From: Simon Davis
Sent: 12 February 2019 11:21
To: 'Kathryn Griffiths' [REDACTED]
Cc: Zoe Knott [REDACTED]
Subject: RE: Burndell Road - Y/98/18/RES

The following concerns were raised at yesterday's meeting by Neil Crowther/Karl Roberts:

PROPOSED SITE PLAN

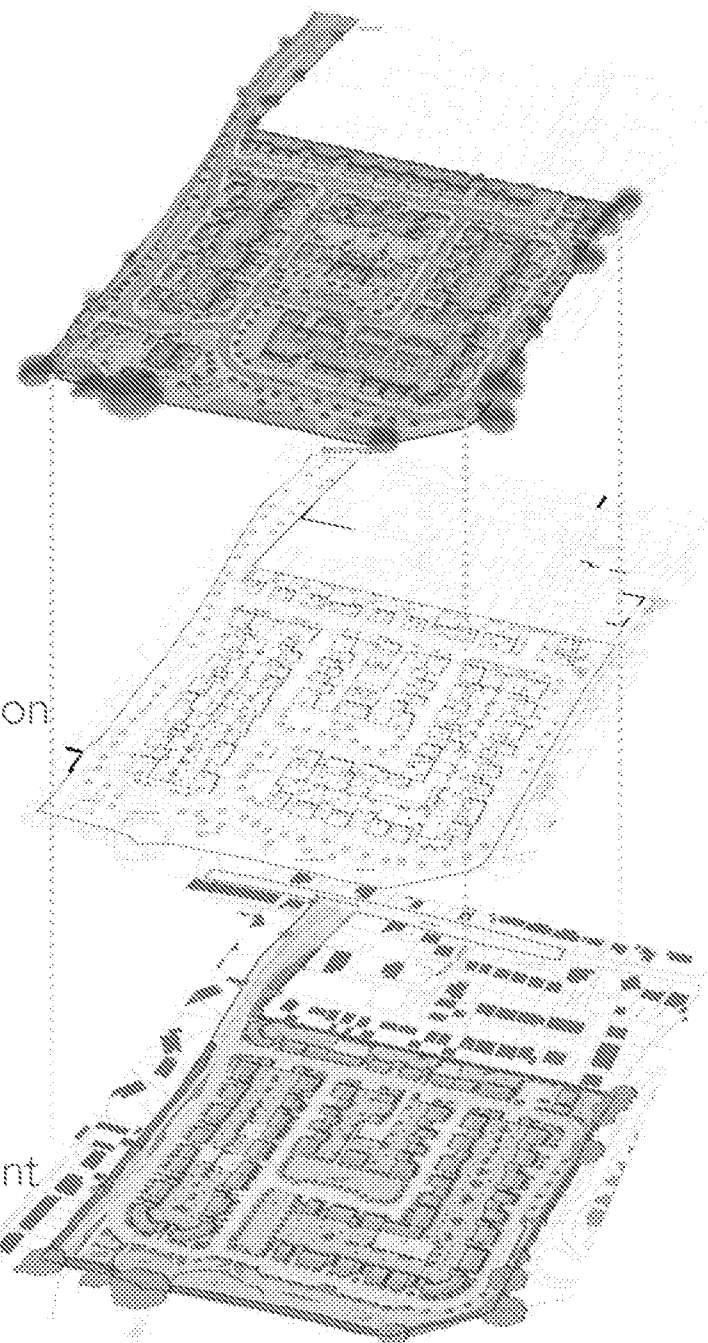
1. We would also not consider the strip of POS along the RH (eastern) boundary to be POS and this should be excluded from the calculation. However, this could be included if the strip was wider as per the indicative layout provided at outline stage (Karl/Neil liked this feature from the indicative layout);

2. There needs to be some kind of link into the adjoining site at the SE corner. I note your points on this matter but can you at least just not include a boundary here so people can walk across grass between the two sites. I note that the indicative layout provided at outline was amended from that submitted at pre-application to create a shared greenspace, fronted by dwellings from both developments with scope for pedestrian and possible vehicular links between the two layouts in addition to the shared greenspace between the developments;

3. Concerns were raised over the location of most of the POS on the periphery and it was not considered to be central enough. However, I do note that this is similar to how it was shown on the indicative plan at outline stage and that there were no objections raised at that time to the indicative design/layout;

4. Concern was raised as to the lack of viewpoints within certain roads in the layout. For example, when driving east down the road between the LAP and plots 37-39, the end view is of a car park plus the rear boundary to 26/27. It was considered better design if the end focal point is of a house frontage. There are other similar examples of this within the layout; and

5. As you are aware concerns remain re the relationship of existing trees to the attenuation pond (I await Tree Officer comments on this).
